M25 Junction 10/A3 Wisley Interchange Improvement Plan – Responses to ExQ1 and comments on WRs.

Further to my letter of 26 November 2019, I write to provide the Guide Association Trust Corporation and Girlguiding Greater London West (“GGLW”) responses to ExQ1 and some additional comments on the Written Representations of other parties.

Drawing Title: **SCHEME LAYOUT PLANS WITH WORKS PLAN OVERLAY REGULATION 5(2)(o) SHEET 10 OF 31**

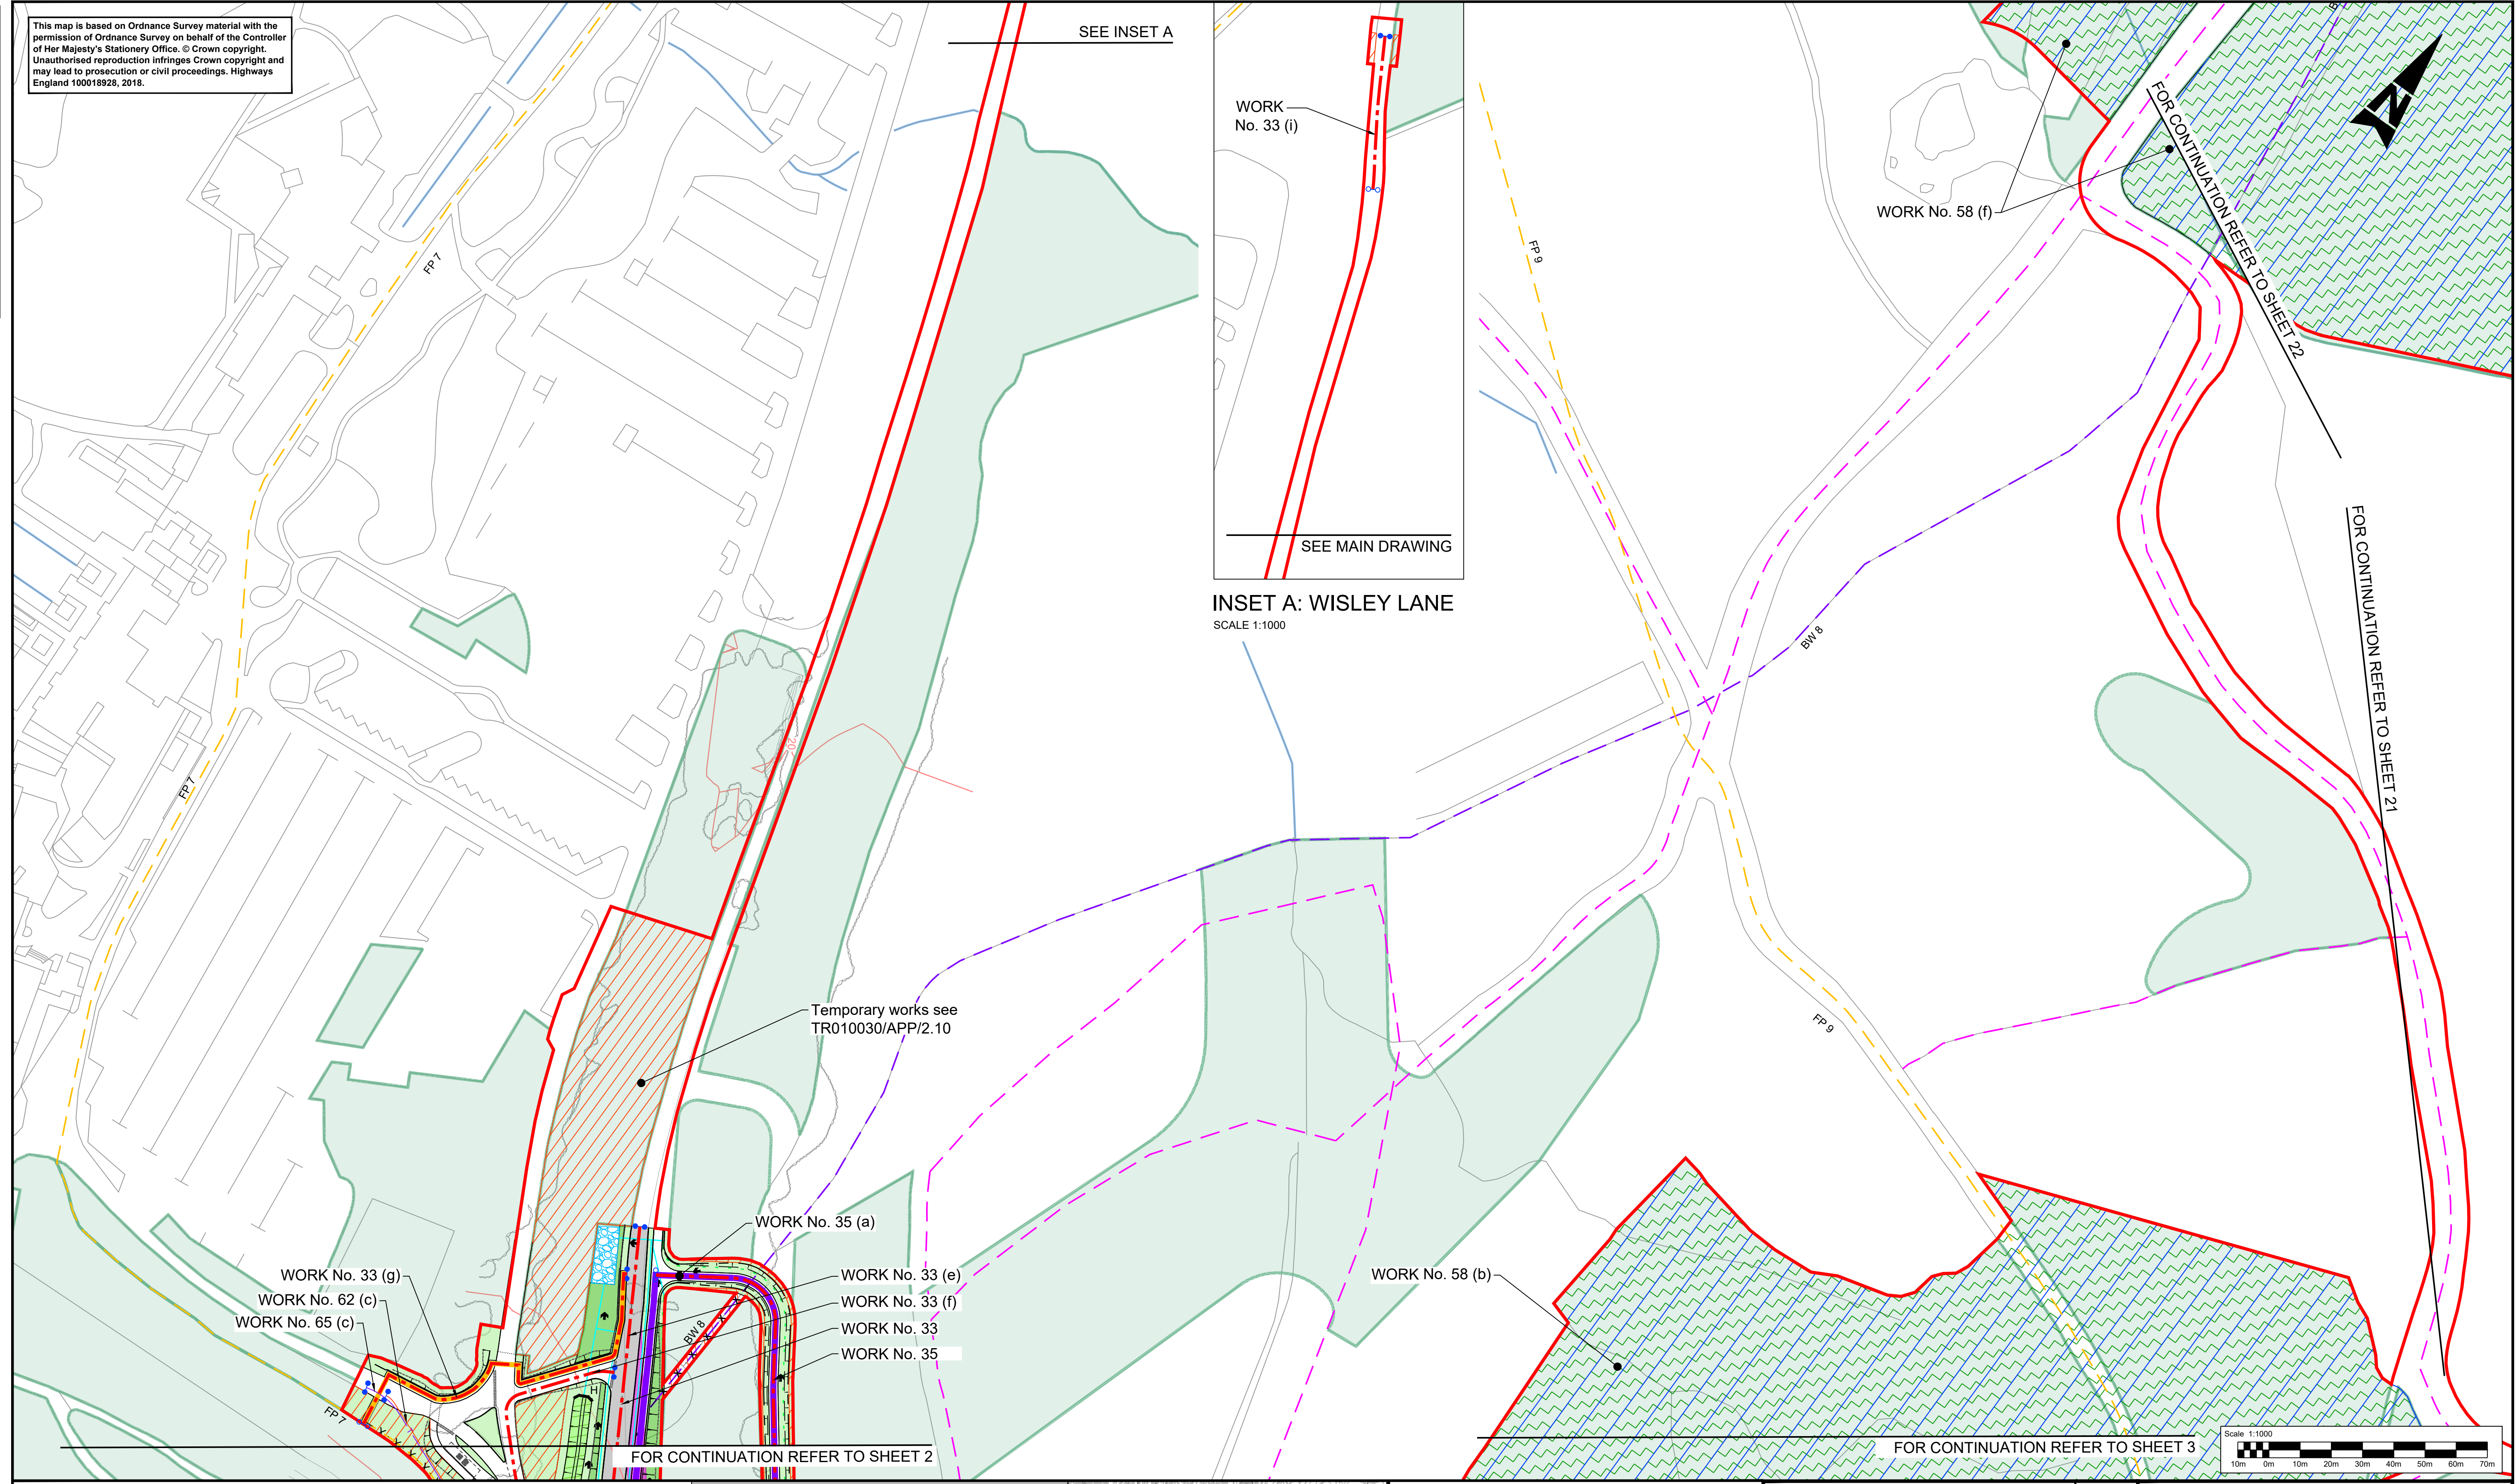
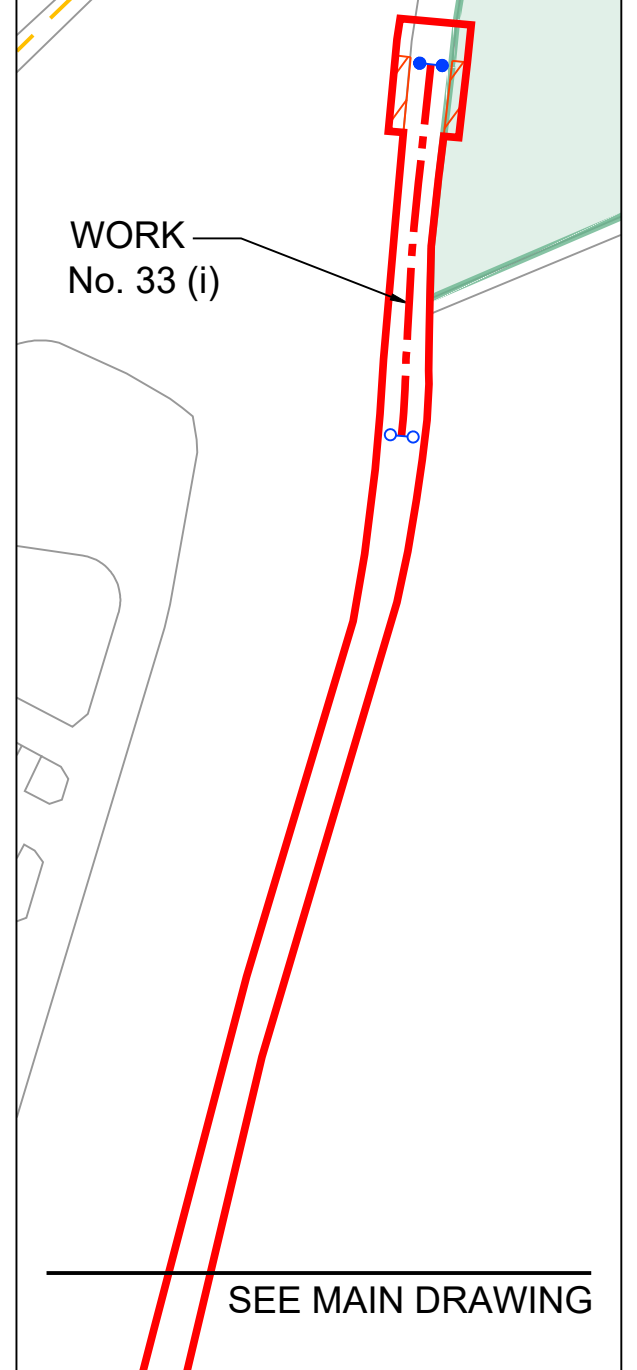
2. The Scheme Layout plans show an electric gate to be provided at the eastern end of the access road as it passes through GGLW’s land but that will not provide an effective form of security because that gate will also have to service residents or occupants of Court Close Farm. GGLW have no way of controlling who stays at Court Close Farm or of confirming whether or not people staying there are ‘child-safe’. As a result, GGLW will need some form of additional security between the access road and those areas where the children will be allowed to camp and/or spend time without direct supervision.

5. The Scheme Layout plans do not show any form of gate within the highway fencing to be provided along the access road, or the form of fencing. GGLW will need:

- (1) An electric gate to be provided to access the southern parcel of land. This will need to be provided next to the main campsite buildings but will need to connect to an additional stretch of track within the southern parcel which will allow access to the campsite area itself.
- (2) Confirmation that the highway fencing to be provided along the edge of the southern parcel will be sufficiently high and solid to secure the Campsite and to block out views into the camping area. The camping area is quite close to the access road on the eastern side of the site and it is a requirement of our safeguarding measures that we can ensure that this area is not overlooked.
